Subject: FW: Stakers Farm, Y/105/19/PL & Y/106/19/L

Subject: RE: Stakers Farm

I have reviewed the revised plans dated which were passed to me on Monday and consider that they are an improvement on the previously submitted proposals. I note reference is made to the interior of barn one and think that it is helpful to finally have more of an understanding as to the proposals. The repurposing of the flint flooring is acceptable and details of how it is to be used within the site will be required. Could this be achieved by way of condition?

Drawing Title
Proposed Plans - Barn 1

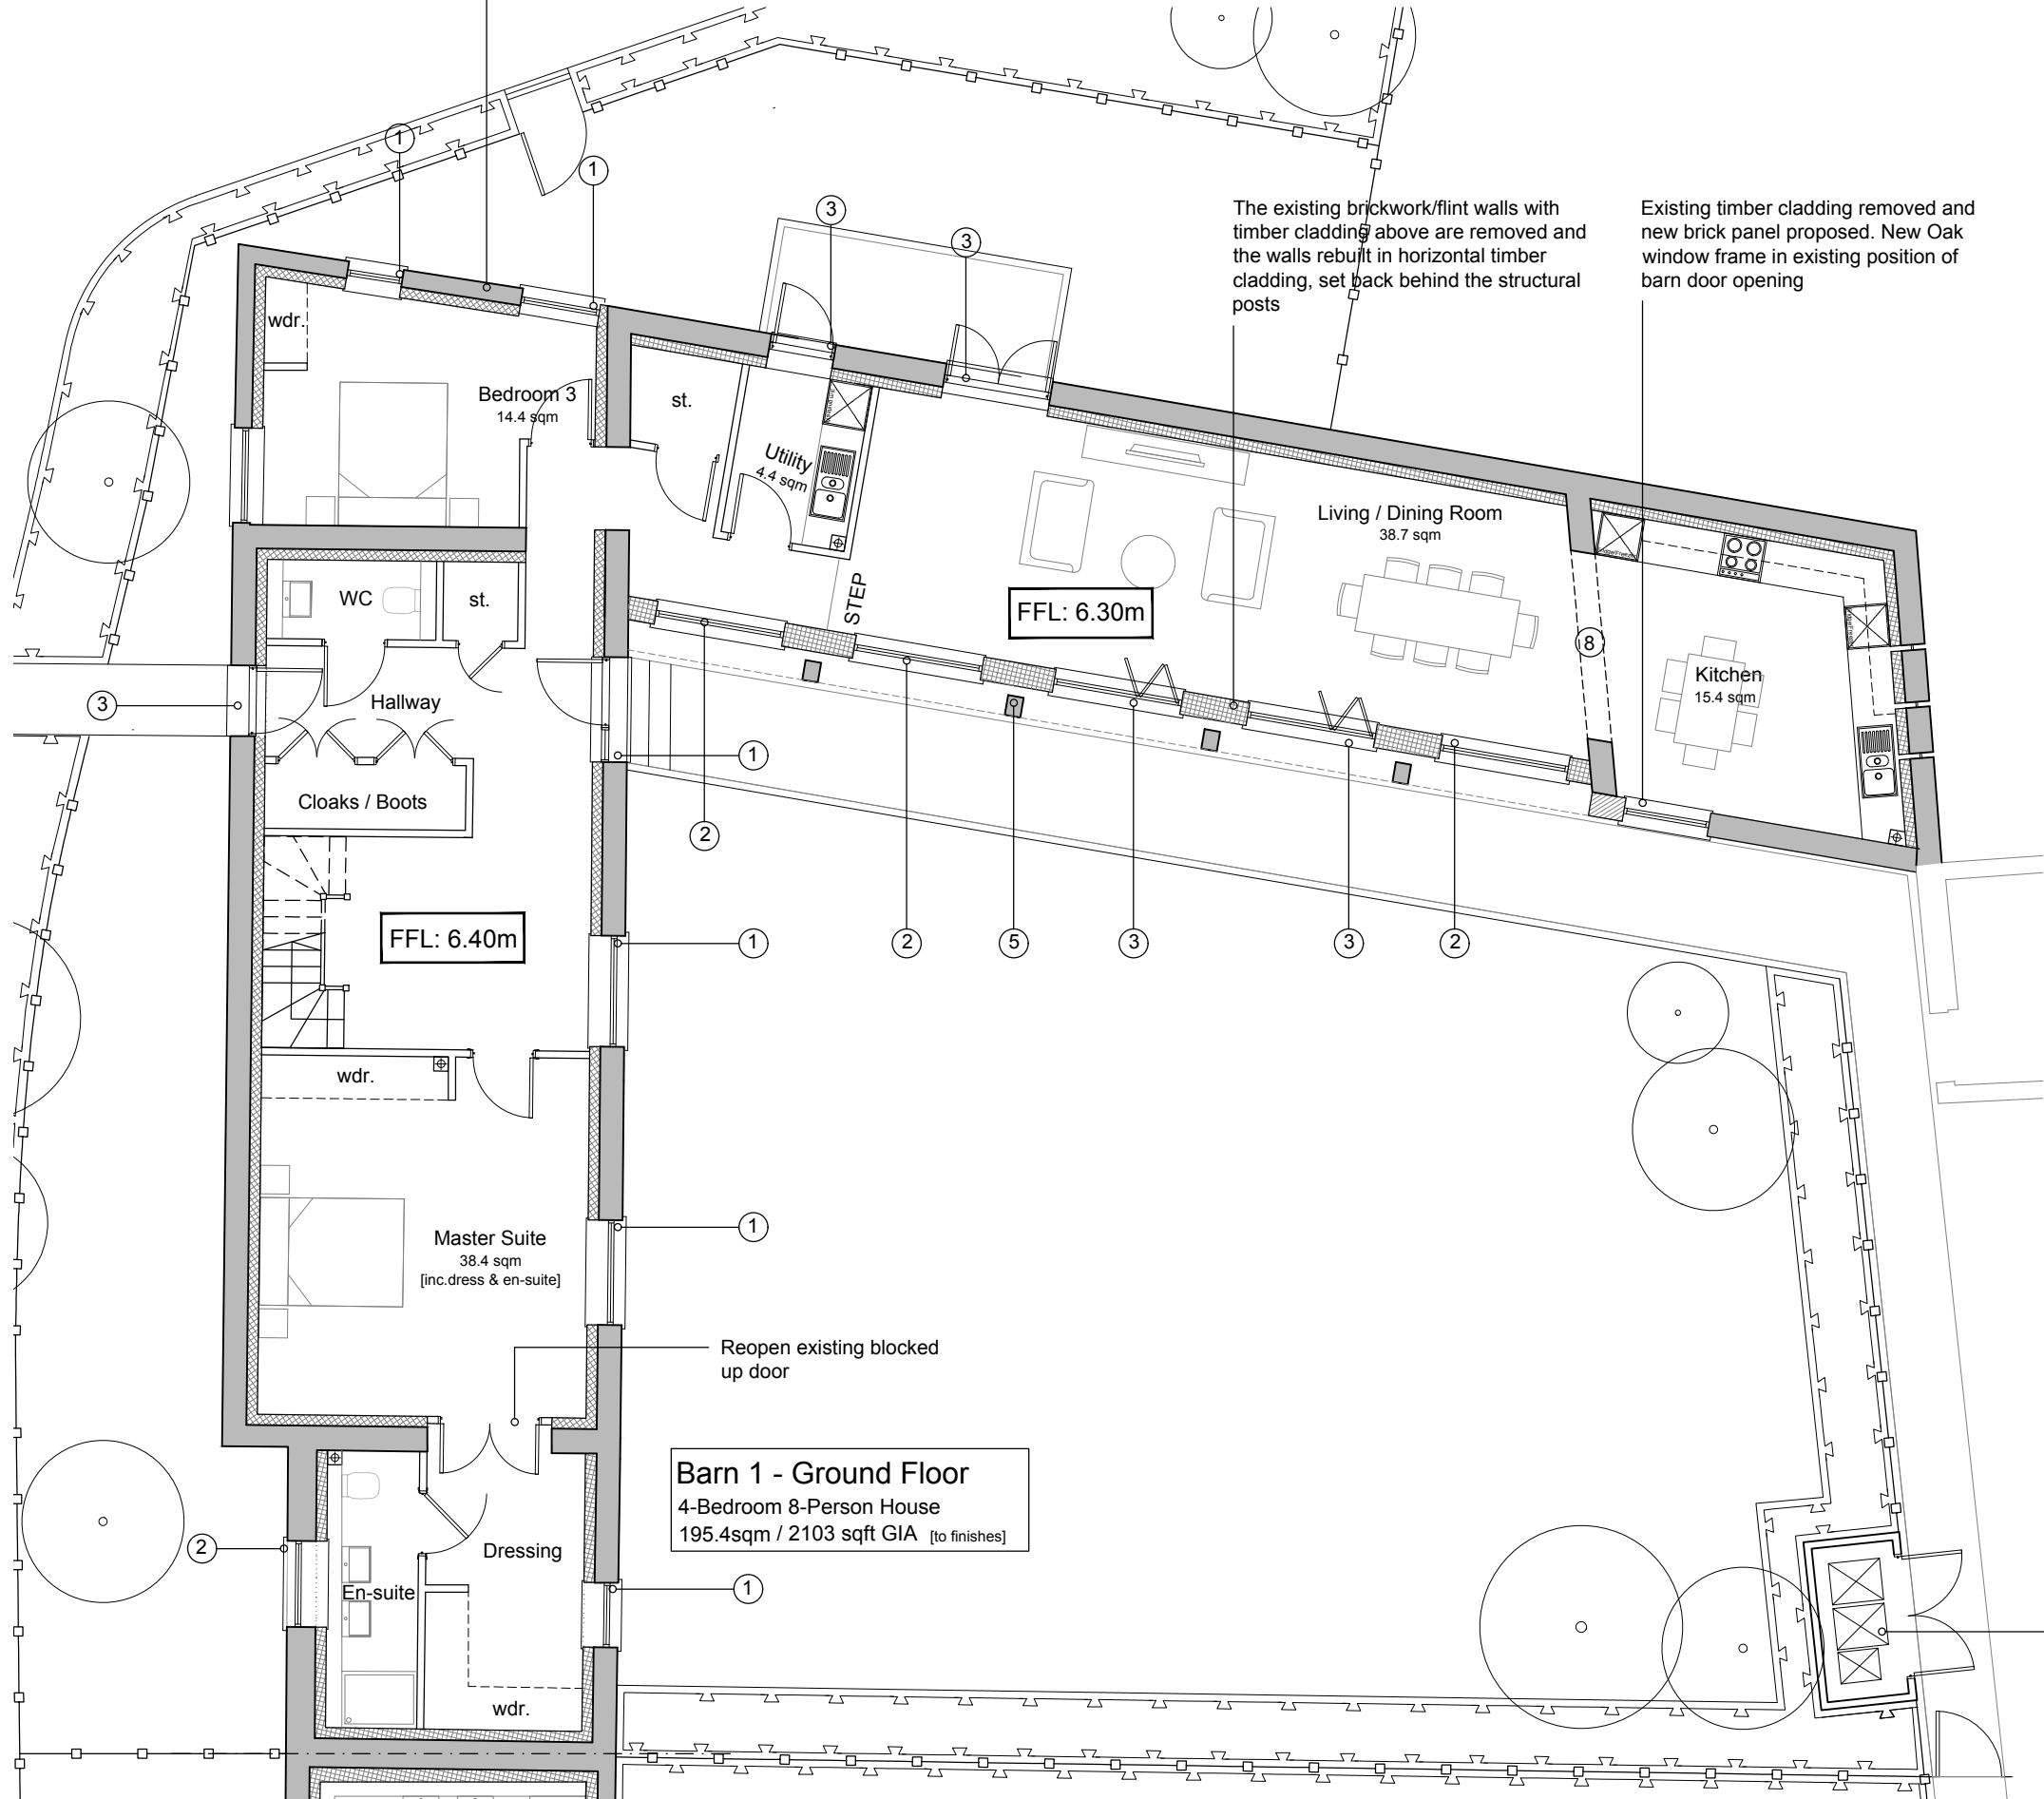
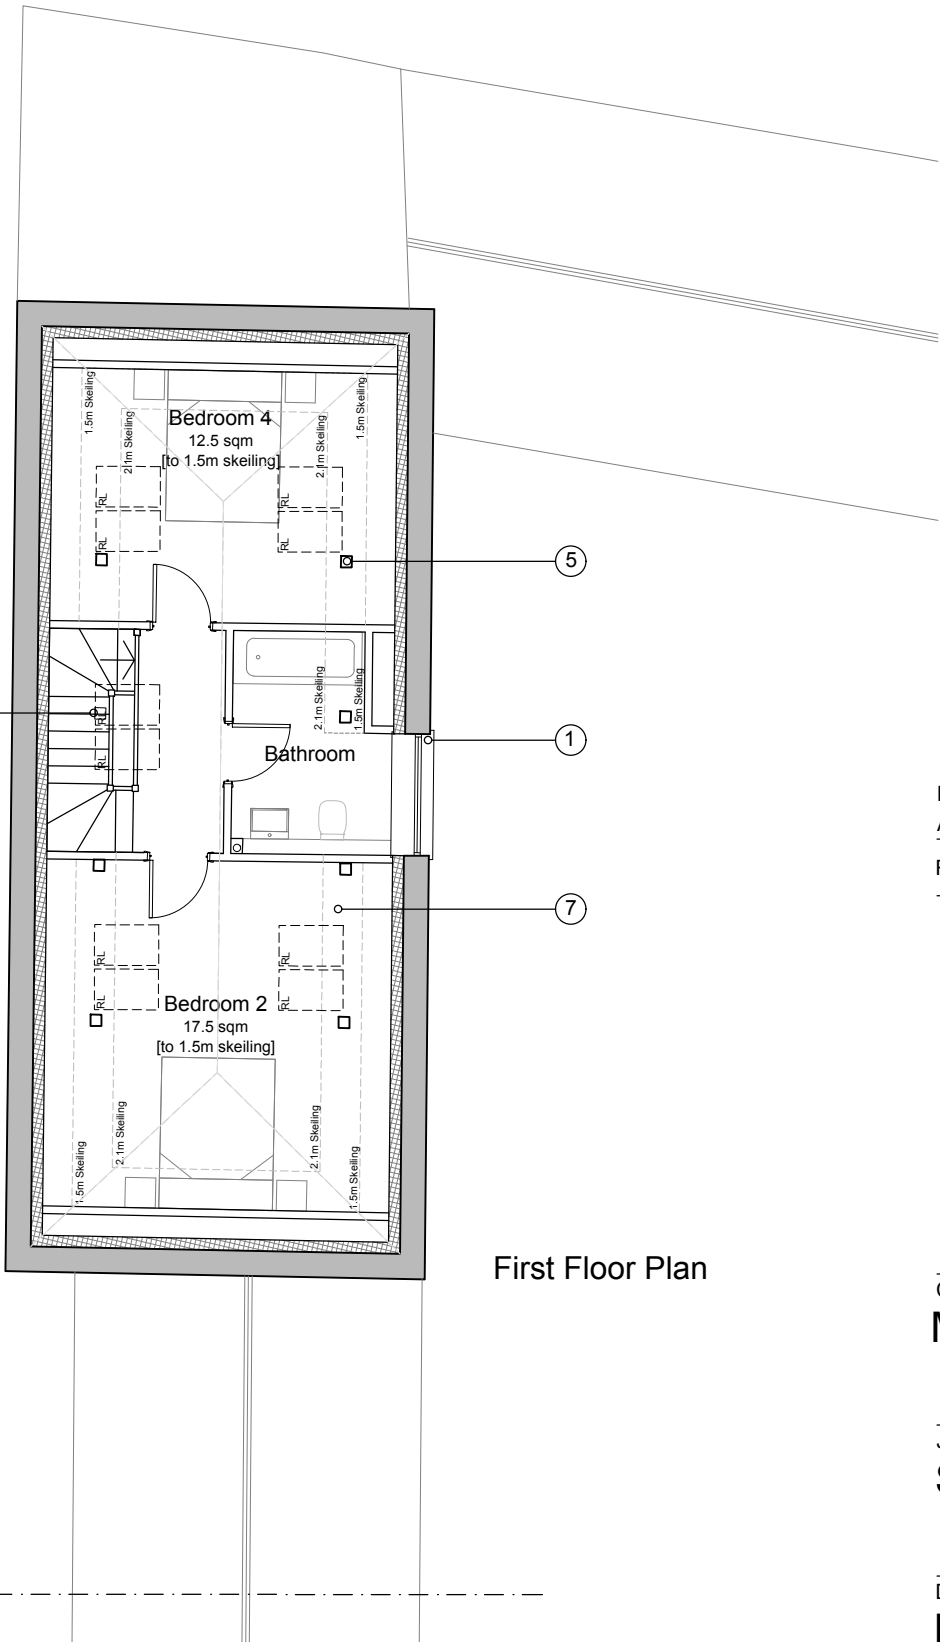
However, I am still concerned regarding the proposals for the walling and the timber ceiling/first floor which are important features of the space, especially in the ground floor area. As such, they should be retained. It could be that some of the walls remain as exposed brick, whilst others are covered with appropriate plaster. Details would need to be provided.

Likewise, as the agent states, the existing timber first floor could be retained as a feature on the ground floor space with new insulation and floor finishes dressed on top in the first-floor area. Further details in this regard can be addressed pursuant to a condition.

Drawing Title
Existing and Proposed Elevations - Barn 1

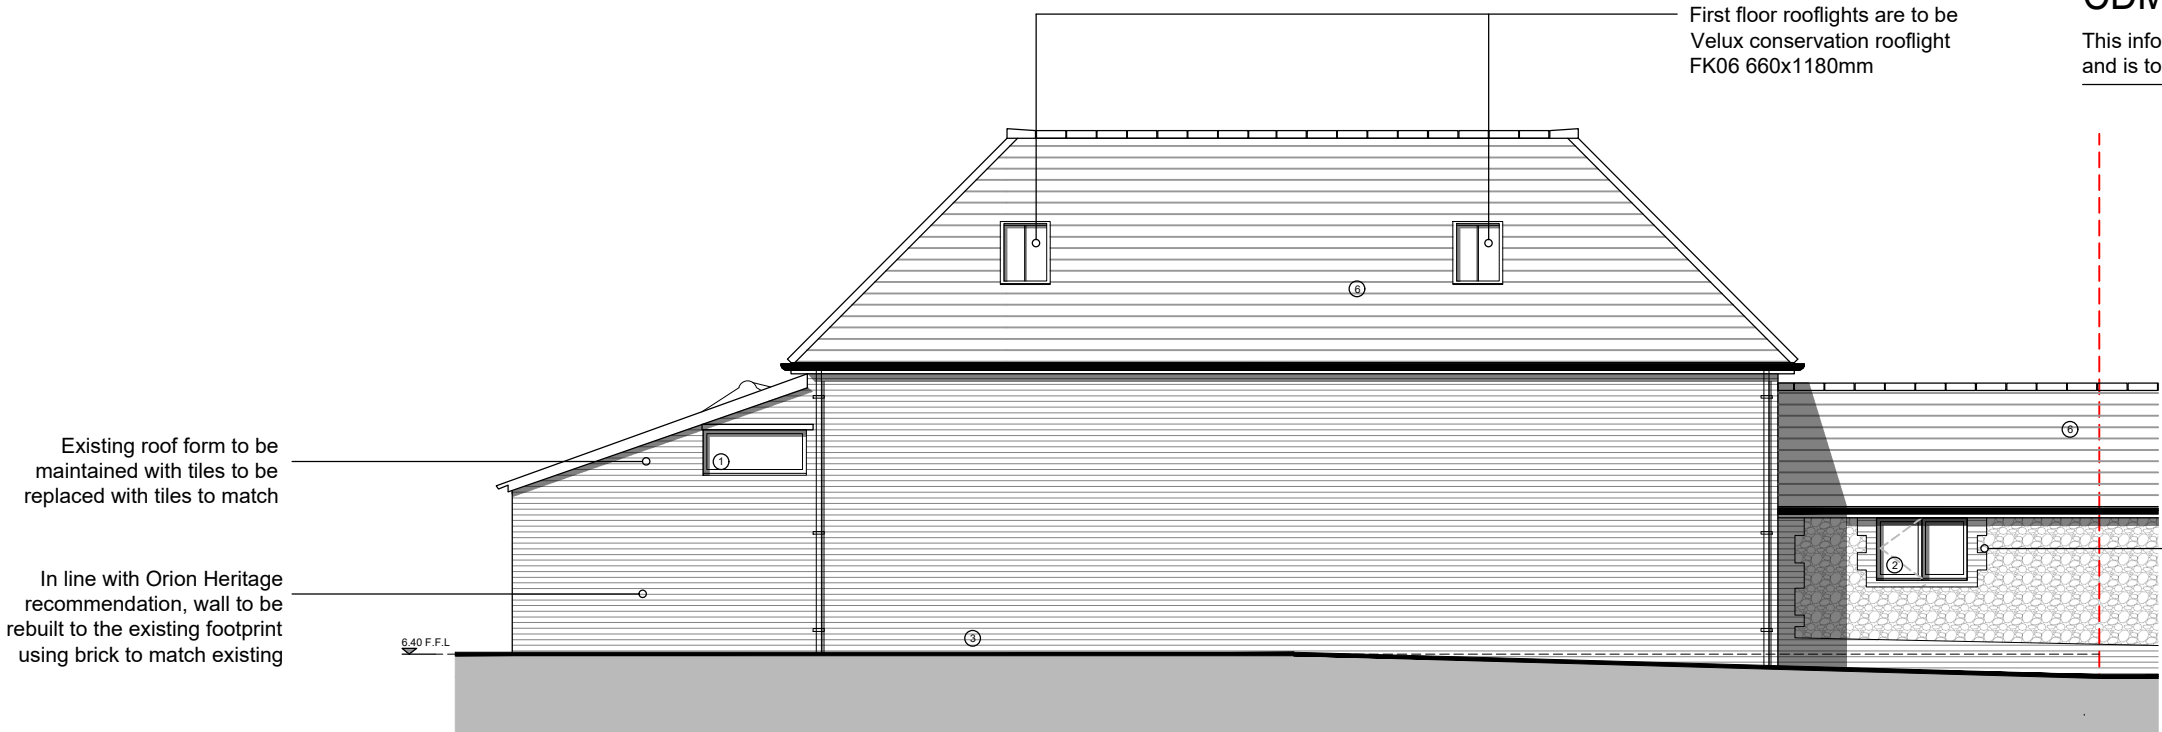
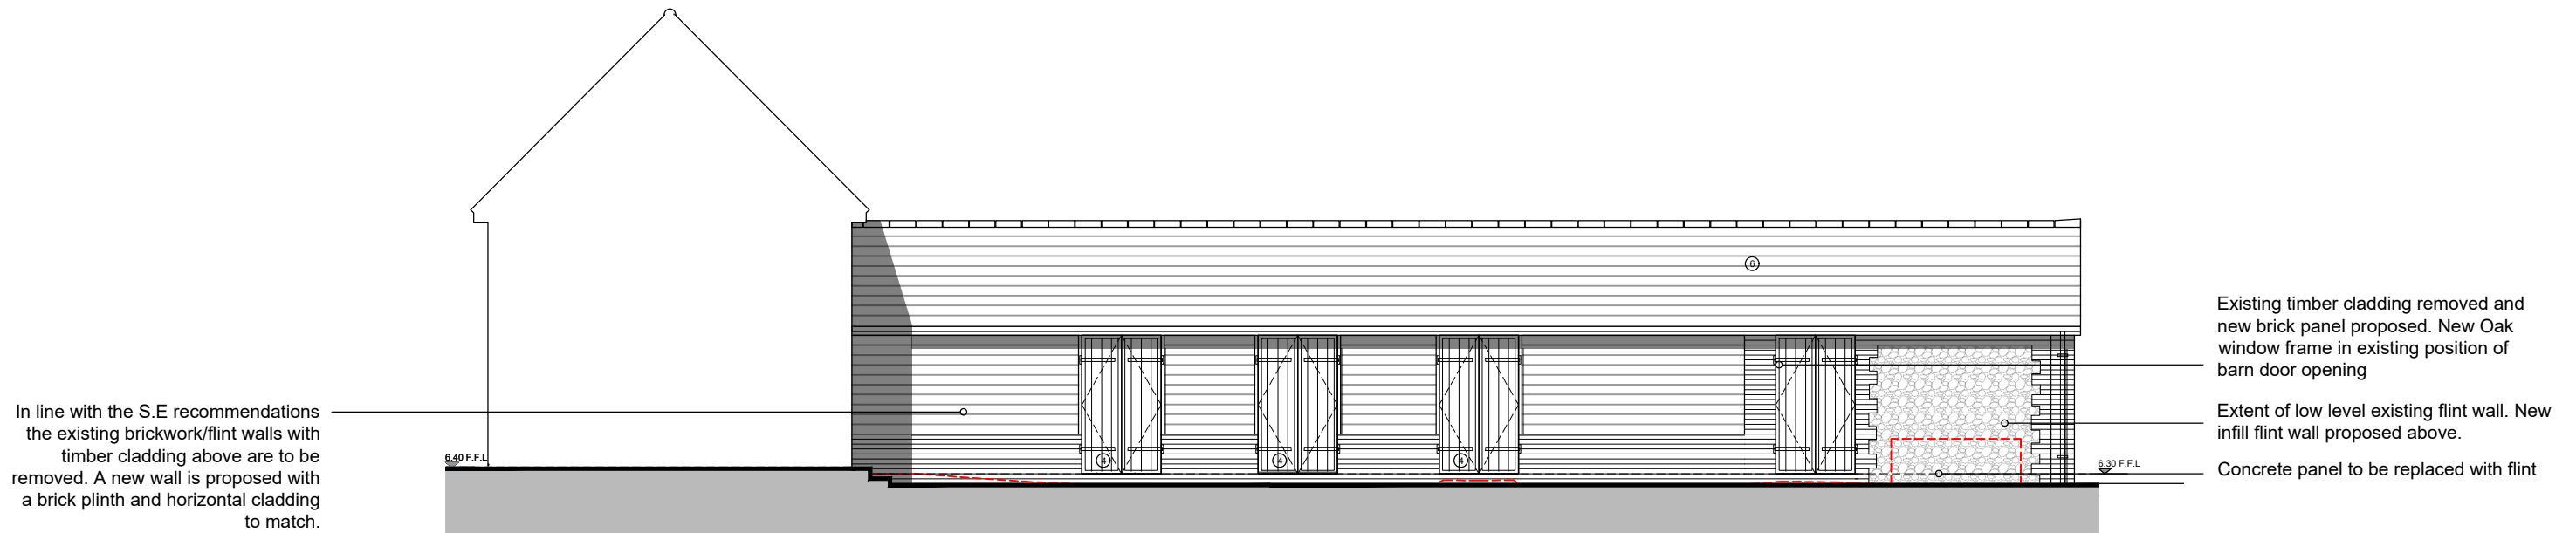
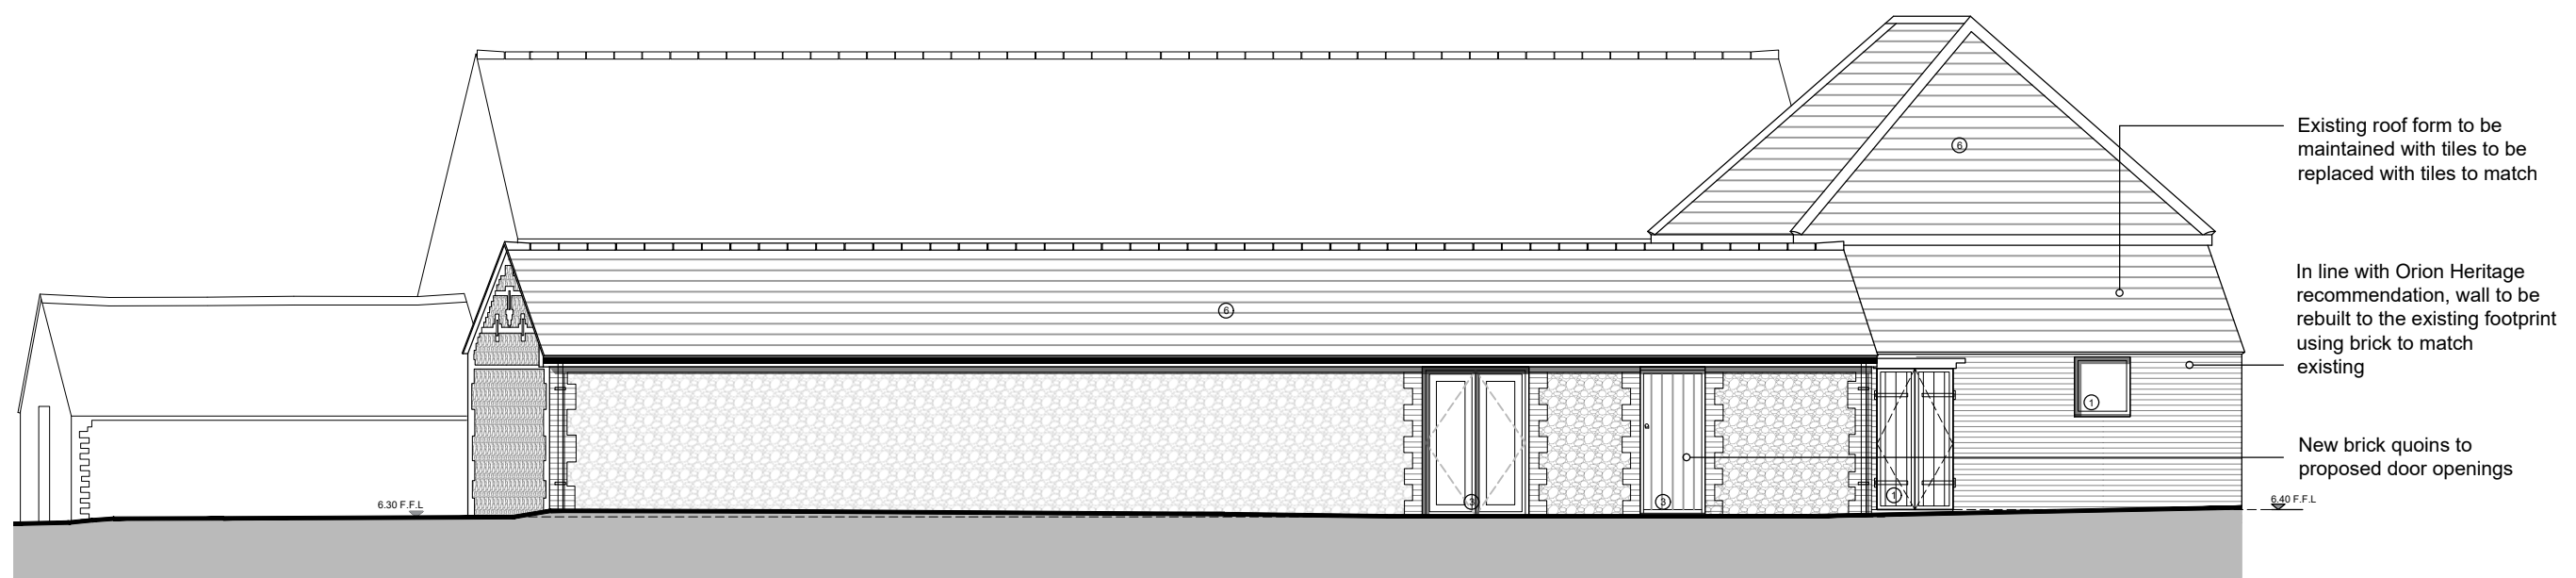
The success of such a scheme will depend upon the quality of the materials used, and landscaping etc as well as minor design details such as the position of the windows and doors in their openings (as indicated on the plans). Such materials and details can be conditioned if the application is to be recommended for approval.

- Amount of conservation rooflights reduced to just two (one per bedroom) located on less prominent north western elevation.
- South elevation amended so size and position of new windows and doors reflect existing.
